SSD-8184

Proposal: SSD-8184 – Fairfield sustainable resource centre expansion

Jemena engineering assessment under AS2885

SEDIMENT AND EROSION  
CONTROL PLAN - SHEET 2 OF 3

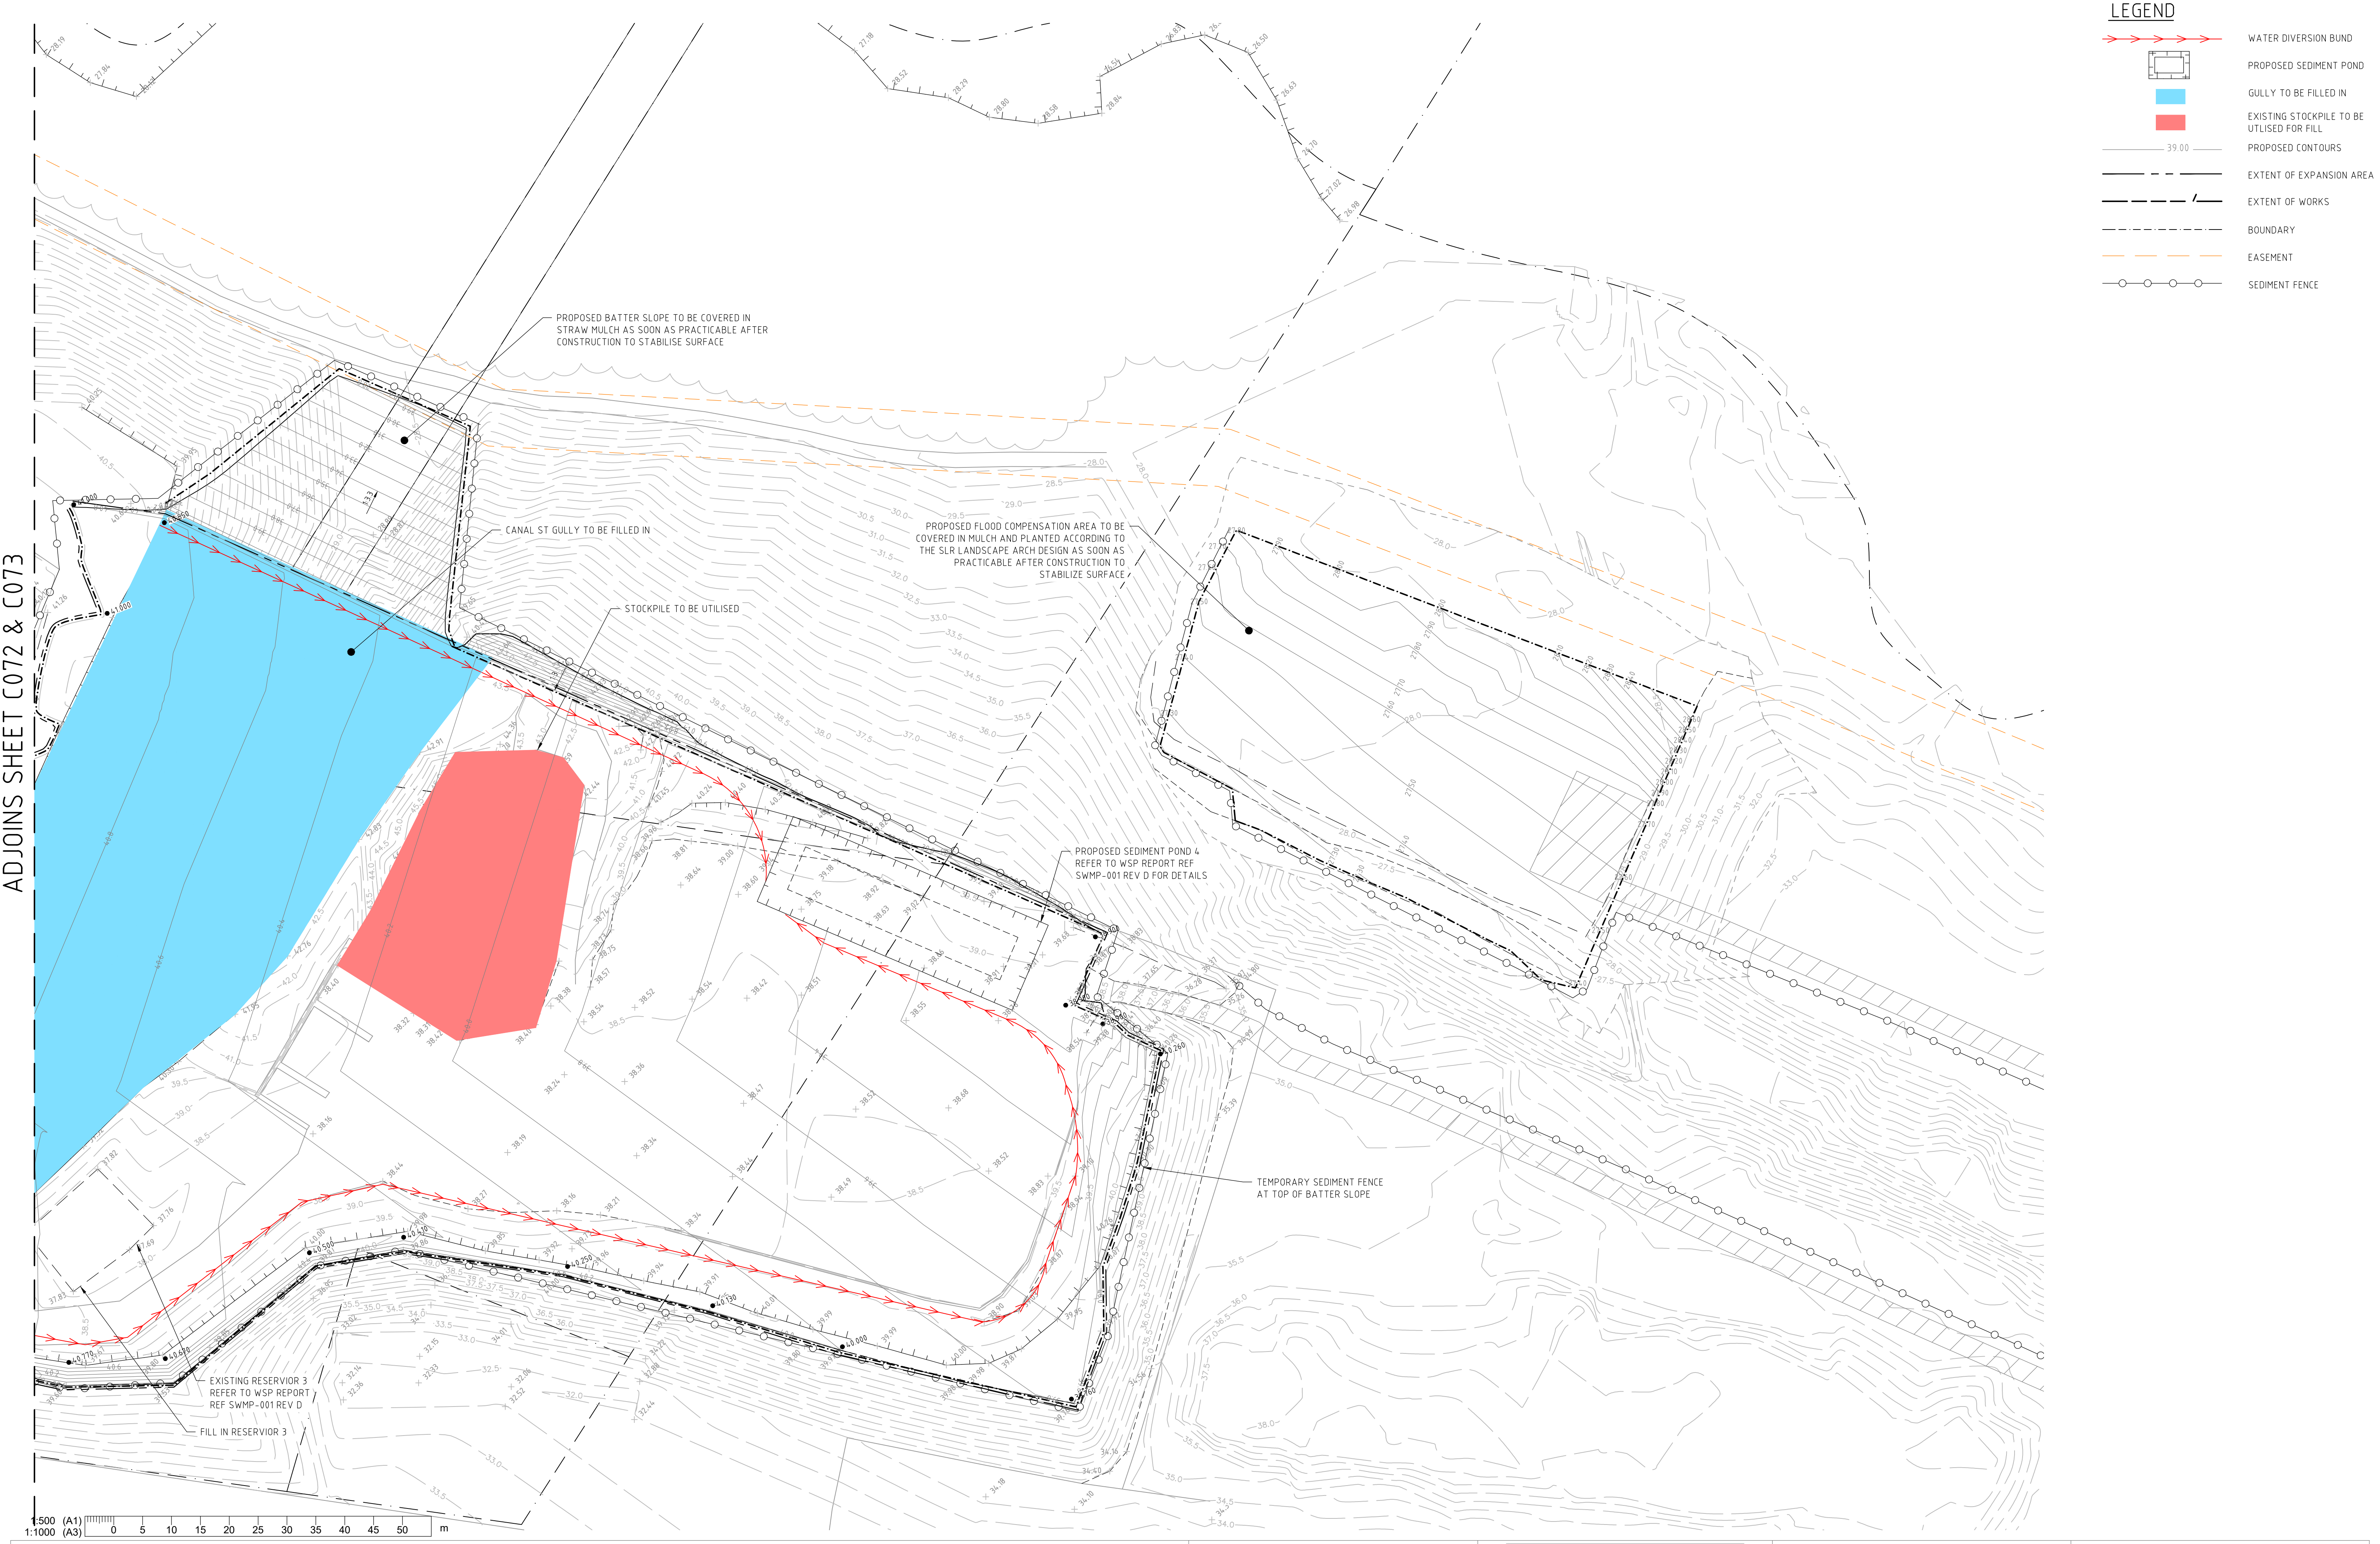
- The proposed sediment pond #5 will require excavation adjacent to the easement. The threat of
- damage to the pipeline coating and possible pipeline damage by mechanical plant during
- construction must be considered.
- The water diversion bund crossing of the pipeline easement requires Jemena acceptance.
- A construction risk assessment will be required to review method of excavation and impact on the
- pipeline.
- The threat of easement erosion caused by water from the Primary spillway must be mitigated by the
- pond design.
- The threat of easement erosion caused by water from the Emergency spillway must be mitigated by
- the pond design.

- The proposed earth works on Canal Road will required excavation adjacent to the easement. The
- threat of damage to the pipeline coating and possible pipeline damage by mechanical plant during
- construction must be considered.
- A construction risk assessment will be required to review method of excavation and impact on the
- pipeline.
- The threat of easement erosion caused by run off from the proposed hardstand on Canal Road
- must be mitigated by the design.

- The proposed Flood compensation area will require excavation adjacent to the easement. The
- threat of damage to the pipeline coating and possible pipeline damage by mechanical plant during
- construction must be considered.
- A construction risk assessment will be required to review method of excavation and impact on the
- pipeline.
- The threat of easement erosion caused by water leaking from the Flood compensation area must
- be mitigated by the design.

Jemena recommends that a Safety Management Study (SMS) be conducted into the additional threats the development may infer on the pipelines and main. This study will identify additional physical controls that must be implemented to reduce the risk to the community in the event of a pipeline rupture.
